Recommendation: Refuse

Applicant: Blue Cedar Homes Limited

Proposal: Erection of 5no two storey age restricted dwellings (55 years) for older people with access, landscaping and associated infrastructure

East Elevation (Front)

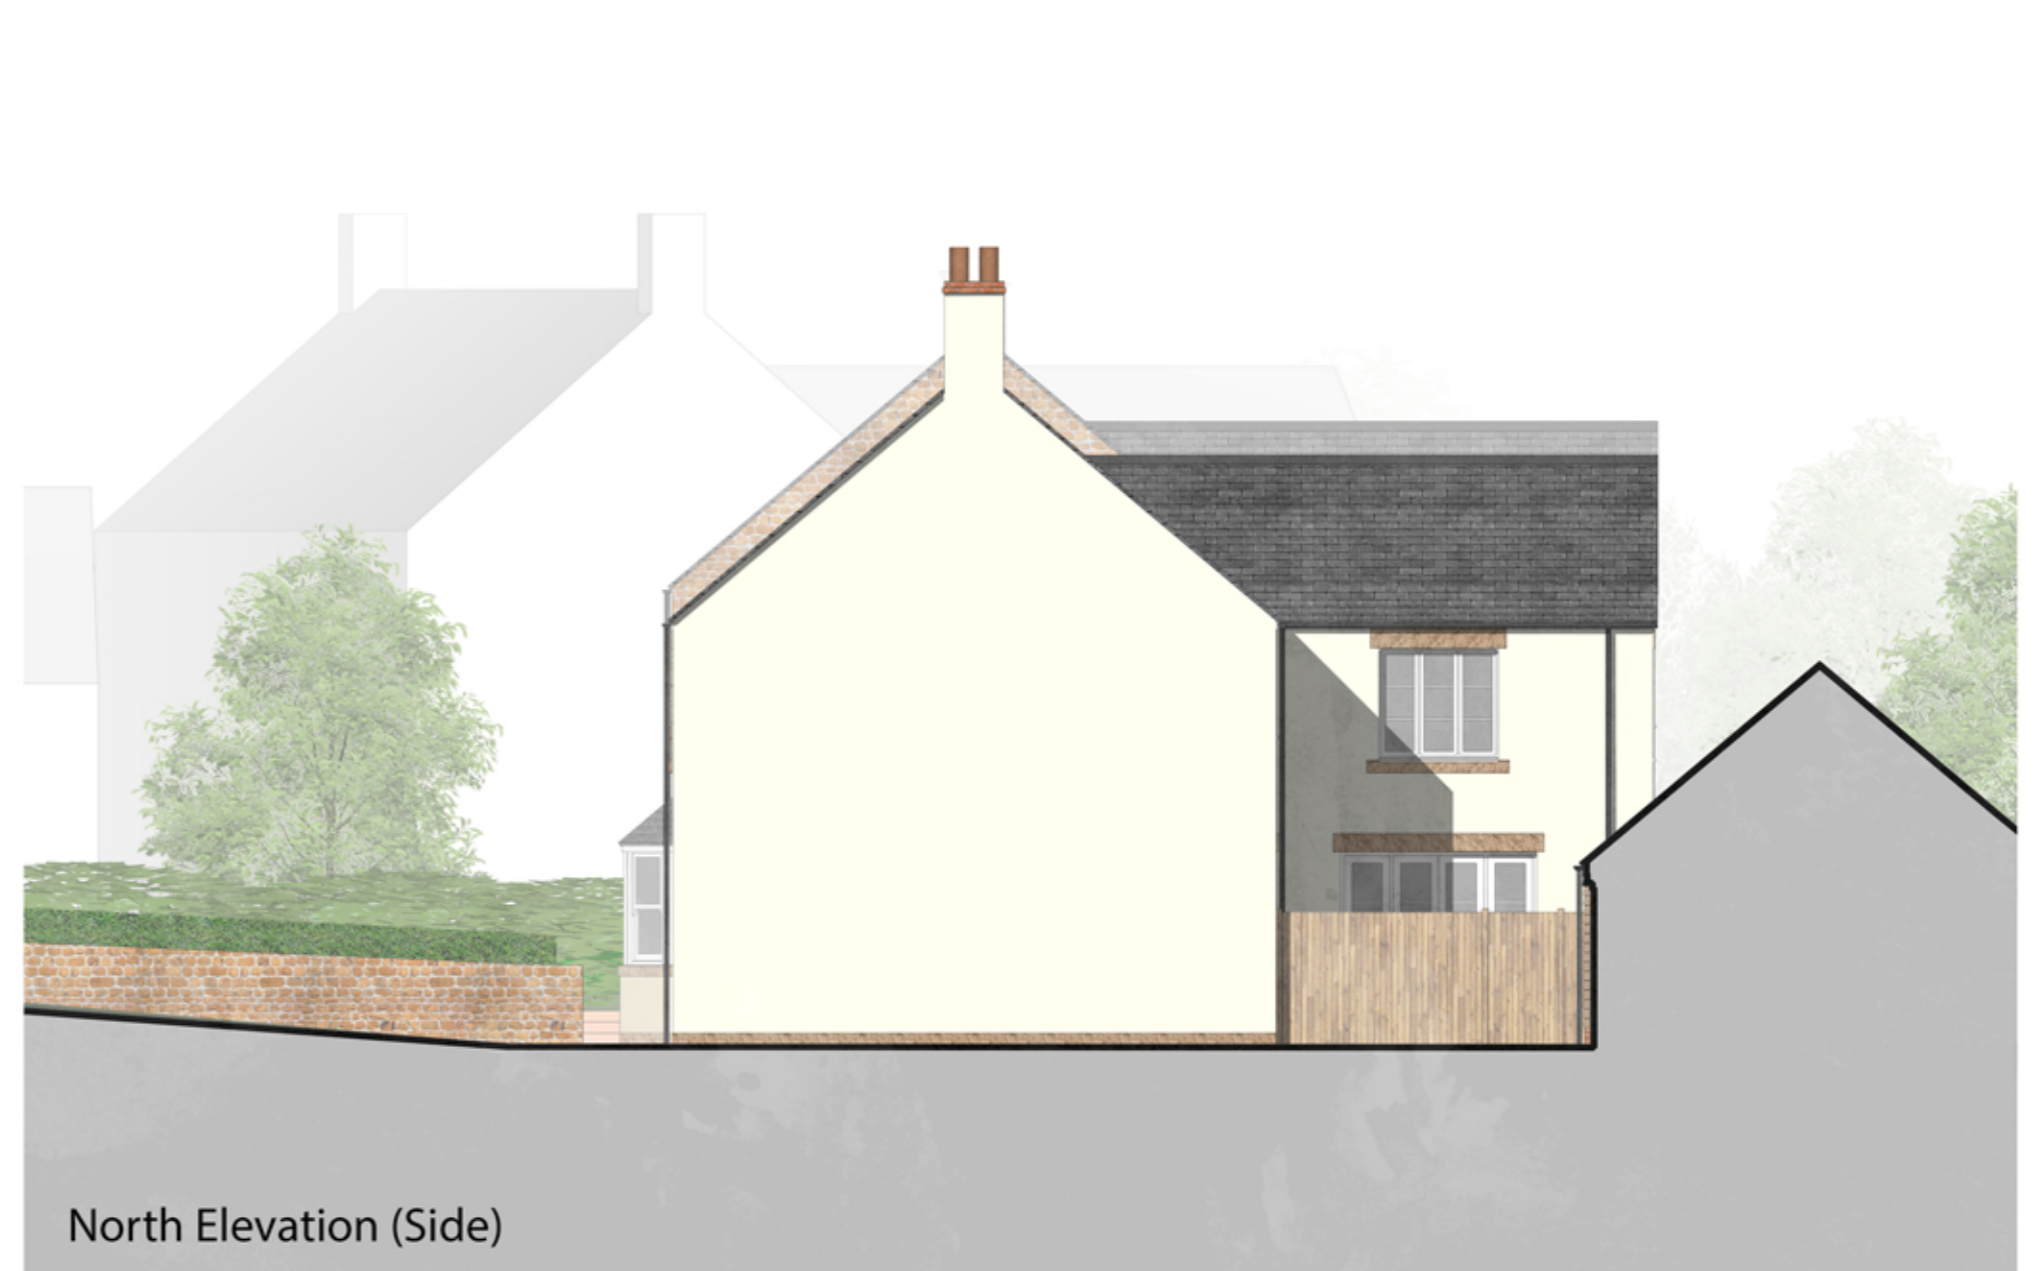
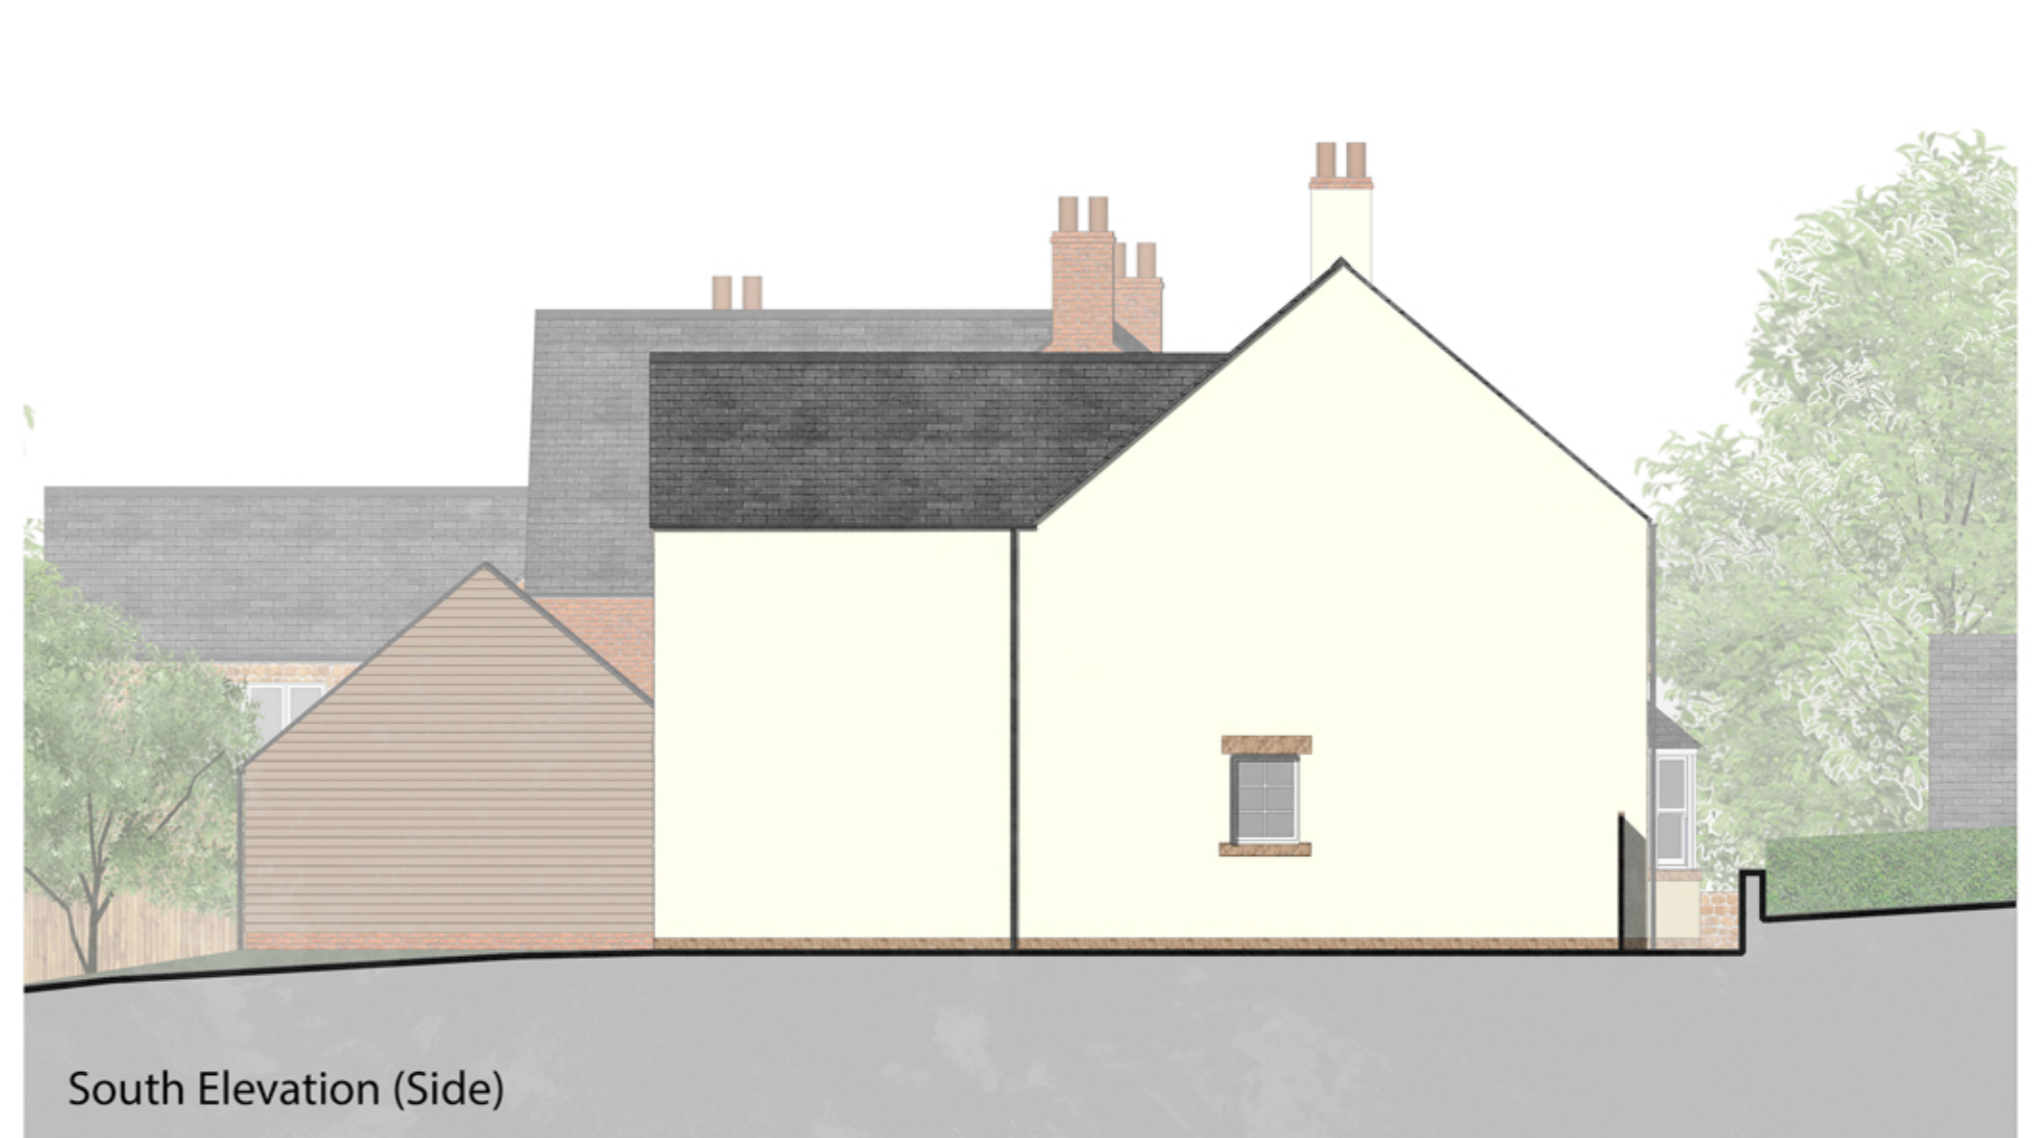
- 8.46 Turning to the design of the dwellings, all 5 would be two storey, with no additional accommodation provided within the roof space. Although it is accepted that the majority of dwellings within the village are of a two-storey design the design of the proposed dwellings are quite different to the properties within the immediate surroundings, particularly in terms of layout and overall context with their surroundings. It is noted in the Inspectors report that “The landscaped context of the village further ensures that it is subservient to the wider countryside with little visible intrusion”. Policy ESD15 requires all new development to respect the traditional pattern of routes, spaces, blocks, plots, enclosures and the form, scale and massing of buildings.

- 8.49 To the north, the proposed plot 5 sits 'end on' to a large, detached property known as Faraday House. The proposed dwelling design has included an unusual roofscape and has hipped the roof away from its neighbour. Assumed to reduce the potential visual and overbearing impact the property may have on the occupiers of Faraday House and curtilage. This dwelling is not considered to be of a design conducive of the locality, however, had the fundamentals of the scheme been acceptable this could have been easily amended. The same applies to the unbalanced fenestration detail of plots 3 and 4.
